From: Harriet Lobacz [REDACTED]
Sent: 08 September 2026 16:15
To: Simon Davis <Simon.Davis@arun.gov.uk>
Cc: Peter Cleveland [REDACTED] Lynn Pack [REDACTED] Sophie Robinson [REDACTED]
Subject: RE: WA/51/26/RES Arb Comments

Thank you for your comments regarding the Arboricultural Method Statement (AMS).

Based on: 5988-005-5551

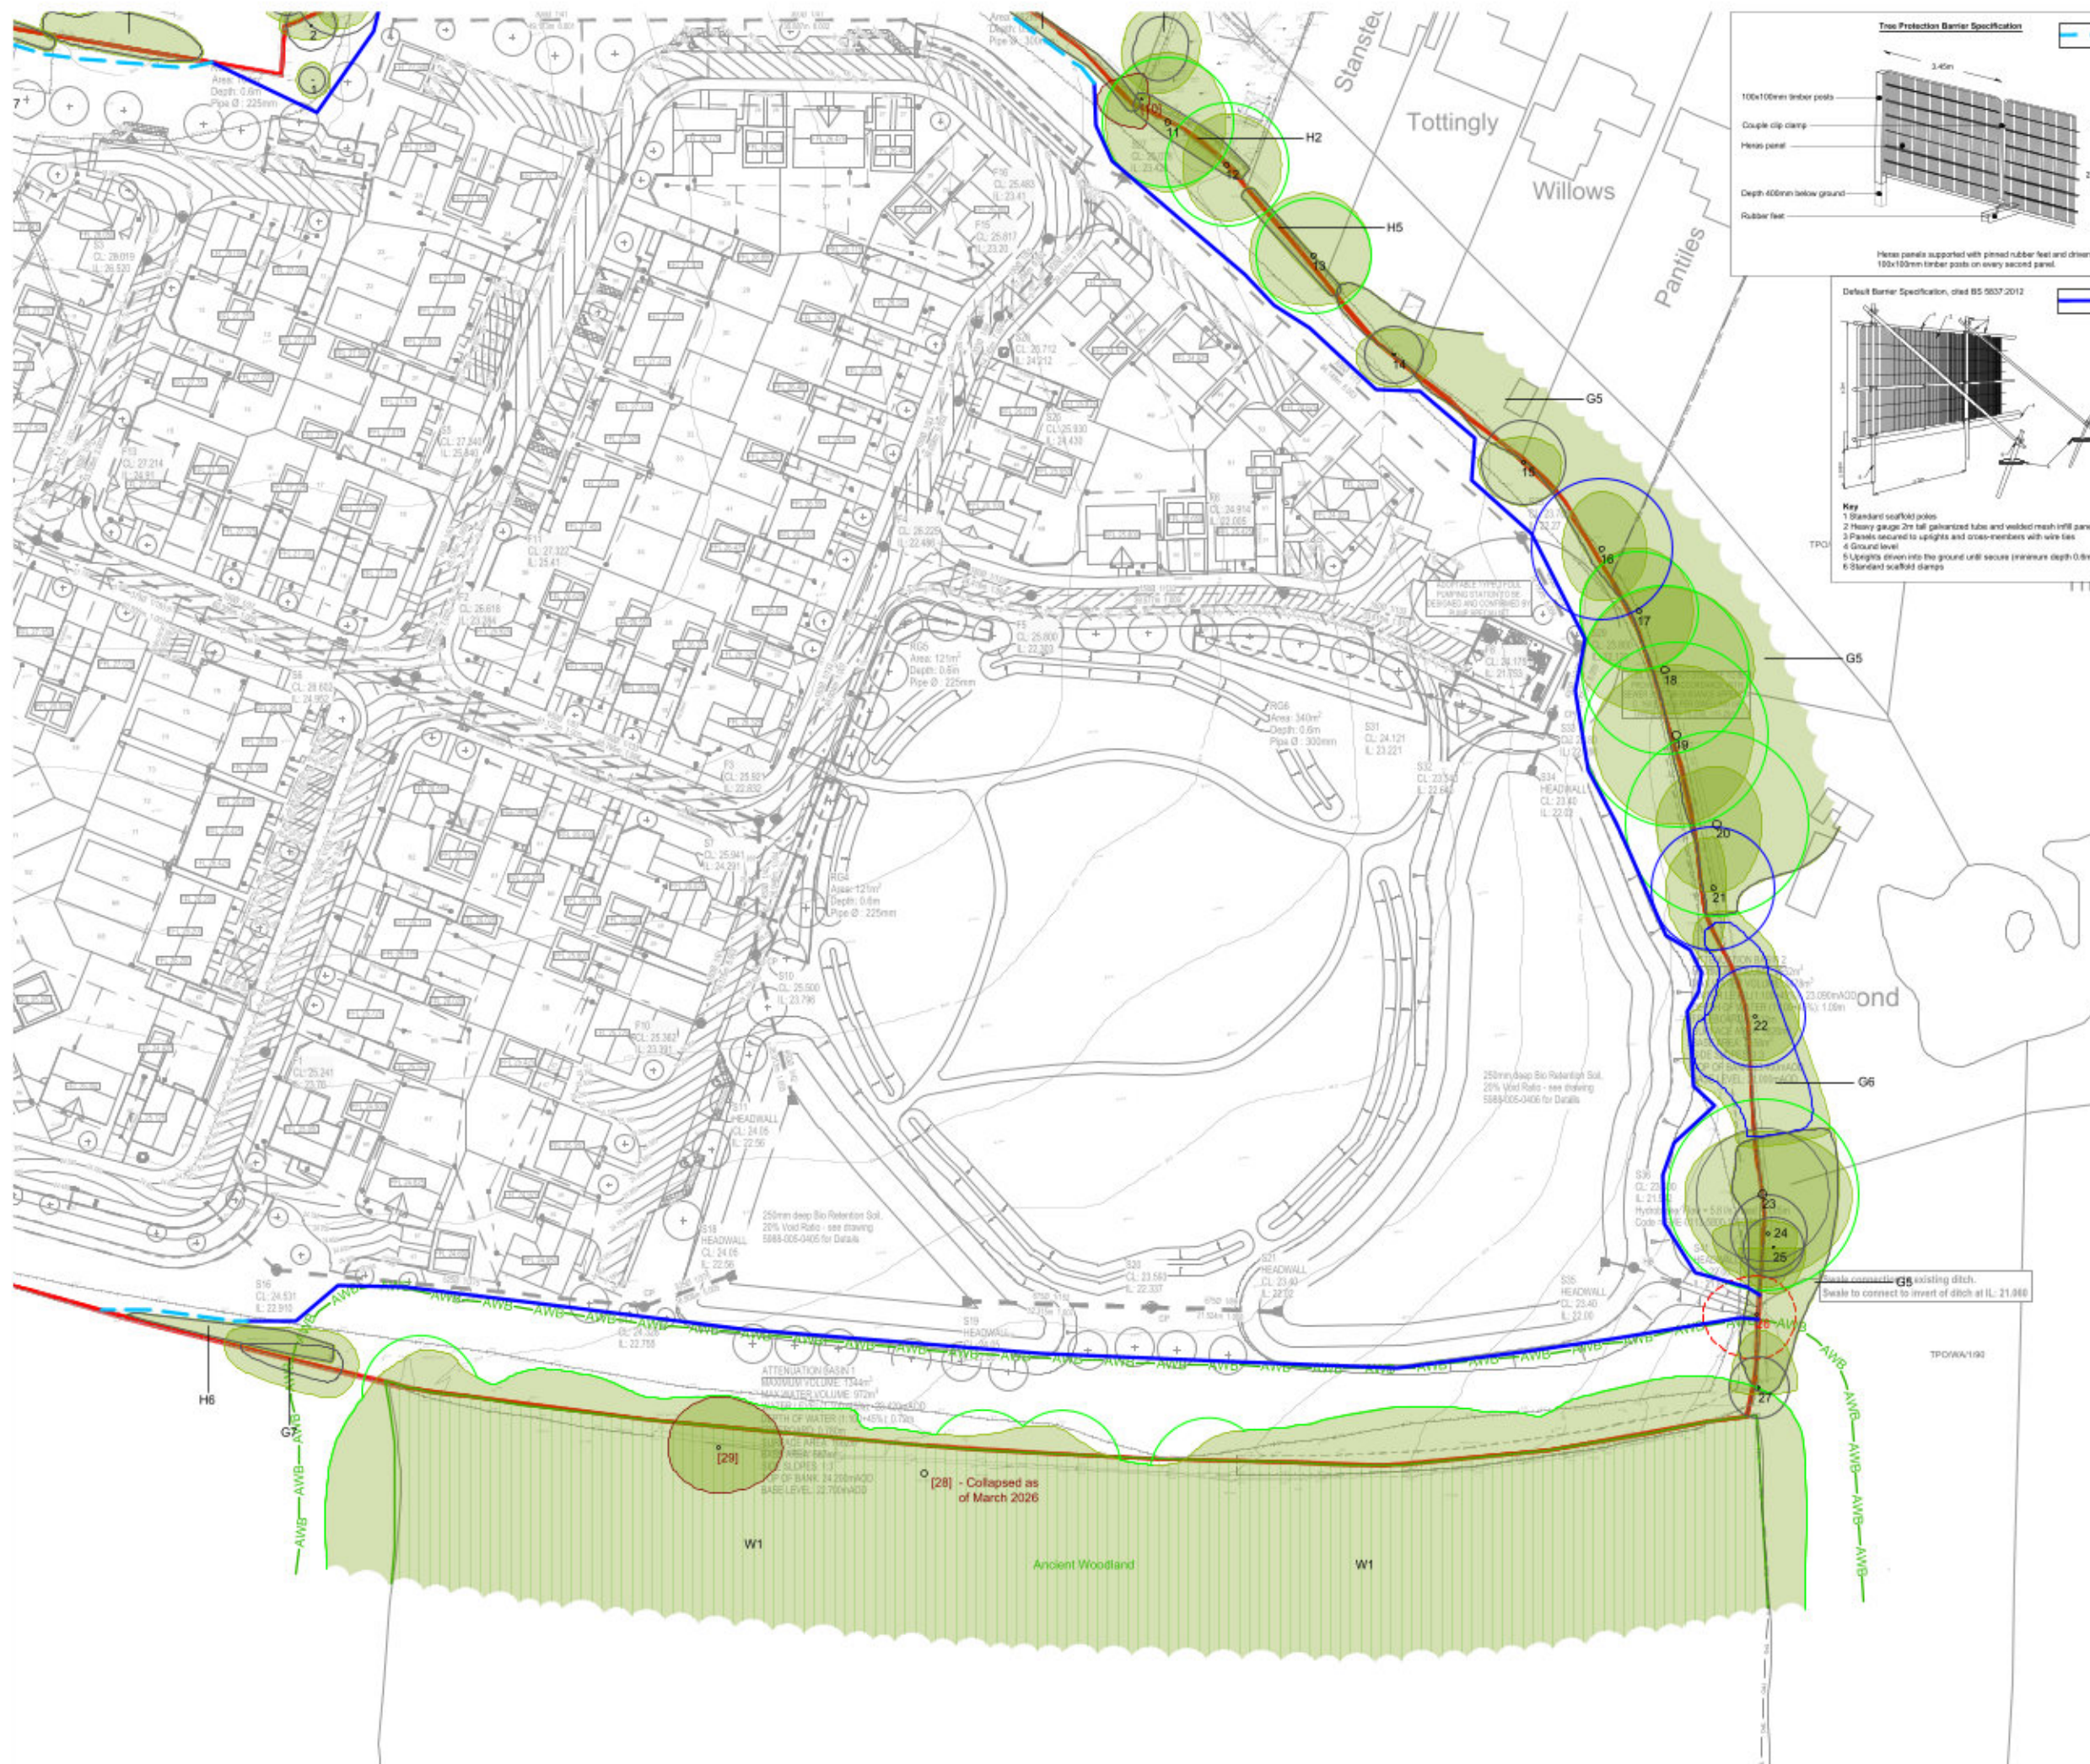
The AMS does not specifically discuss the Tree Preservation Order because the protected trees are unaffected by the proposed works. The relevant TPO trees are identified within the Tree Protection Plan and remain outside areas of impact. Equally, the high-value trees identified as T11, T12, T13, T17 and T20 have been afforded specific consideration throughout the design process. Indeed, the drainage layout was amended specifically to ensure that the final scheme avoids adverse impacts on these trees.

We also note the concerns raised regarding the relationship between the proposed SuDS infrastructure, the Ancient Woodland buffer and Root Protection Areas. The Ancient Woodland is afforded a minimum 15-metre buffer, with the nearest built development located approximately 18 metres away. This exceeds the buffer distance that was considered acceptable by the Inspector during the appeal. Whilst limited SuDS infrastructure is proposed at the edge of the buffer, it remains approximately 5 metres beyond the nearest Root Protection Areas. The Government guidance referenced within the Arboricultural comments acknowledges that appropriately designed infrastructure may be acceptable within buffer areas where root protection is maintained. The scheme has been designed on this basis and avoids encroachment into the relevant RPAs.
